Consultation Response from KC, Conservation & Design
2023/93385 adj, 2, Holmclose, Holmebridge, Holmfirth, HD9 2NJ
Erection of detached dwelling
Date Responded: 12.12.2023
Responding Officer: S Pickles
Responding Ref:

The application site is located to the immediate east and within the setting of the Grade II Church of England Primary School. The impact of the proposals is therefore the consideration of the impact on the setting of the listed building.

Proposed Plans and Elevations

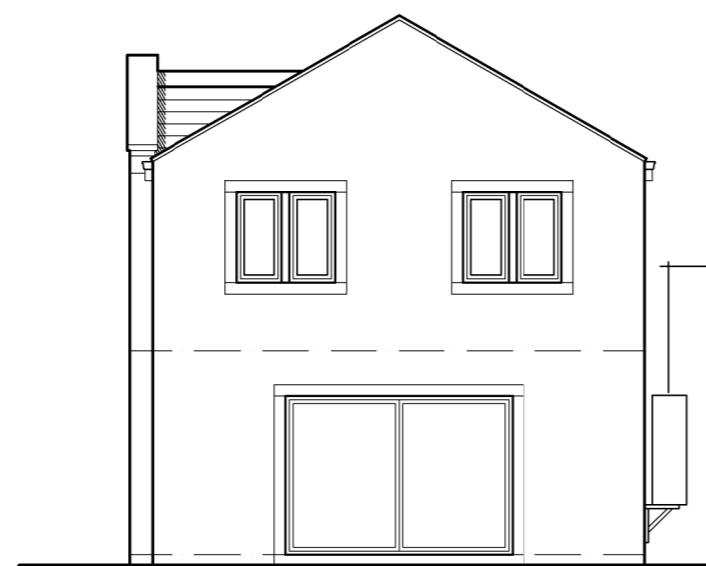
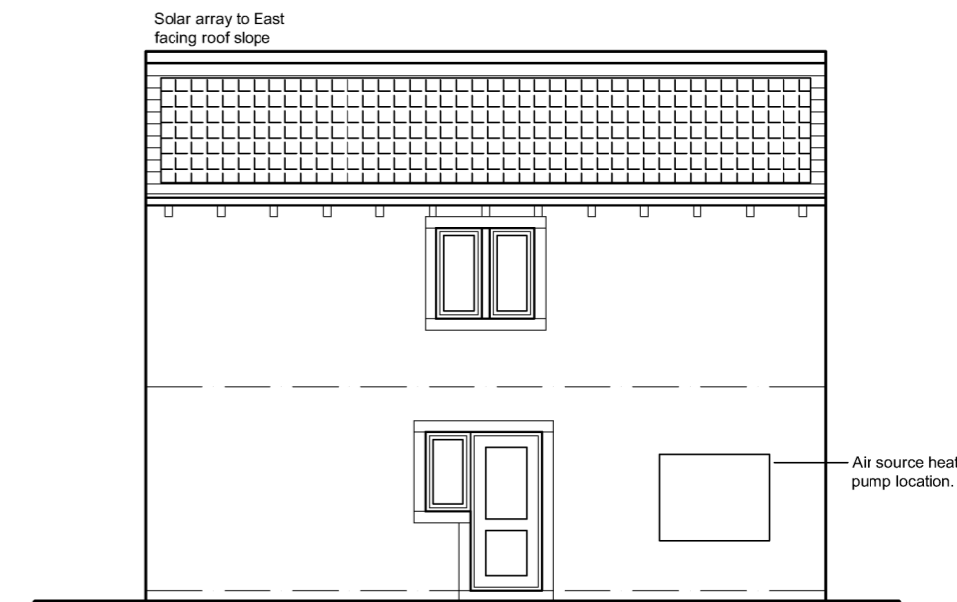
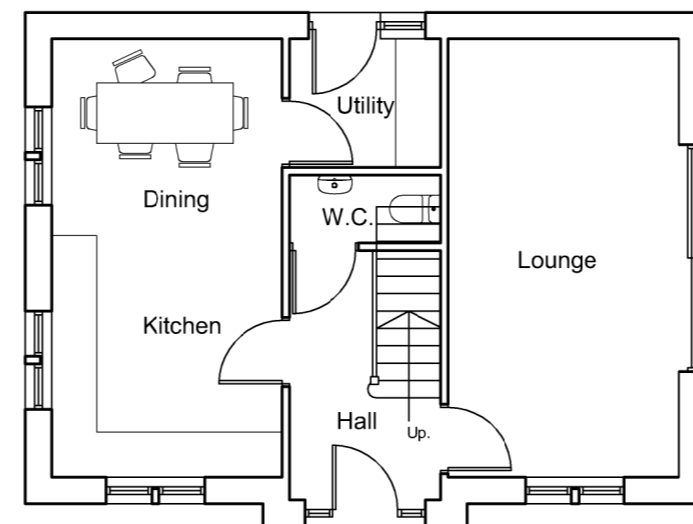
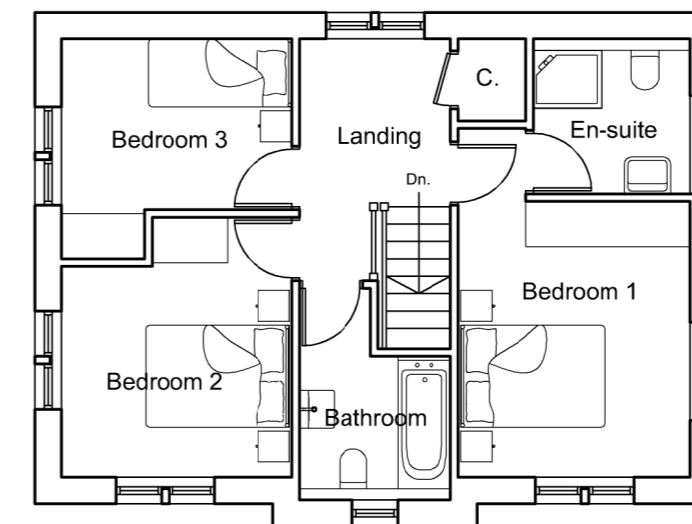
Having assessed the proposals we can see that some amendments have been made to the previously submitted withdrawn schemes and the building footprint has been slightly reduced, pulling it in from the roadside. The submitted statement sets out that they have attempted to draw some design elements across from the listed building, seemingly to provide some form of mitigation for the impact on the setting of the listed building. They have also stated that the material palette has considered using natural stone and stone roofing slates, again as a means of providing design mitigation. The details also set out that the existing hedging and planting would be retained to provide some form of natural screening.

While we recognise that there have been changes from the previously submitted schemes, this does not account for consideration of the impact on the setting of the listed building and the streetscape. The application, as mentioned, does appear to be attempting to overcome the impact on the setting by providing design and materials mitigation, however, this alone would not overcome the considered impact. We would also question the layout of the scheme and the intention of retaining the hedging and planting. Given the location of the proposed dwelling, we consider that it is likely that some of the planting and hedging would be impacted by the development of the dwelling and would likely either be lost or deteriorate as a consequence, thus removing the considered natural screening.

Overall, we consider that the proposals would have a harmful impact on the setting of the listed building. While there has been more consideration for the footprint and design, this would not be sufficient to overcome the considered harm. Having reviewed the justifications for the proposed development we do not consider that there is a clear and resounding justification or sufficient public benefits which would outweigh the harm.
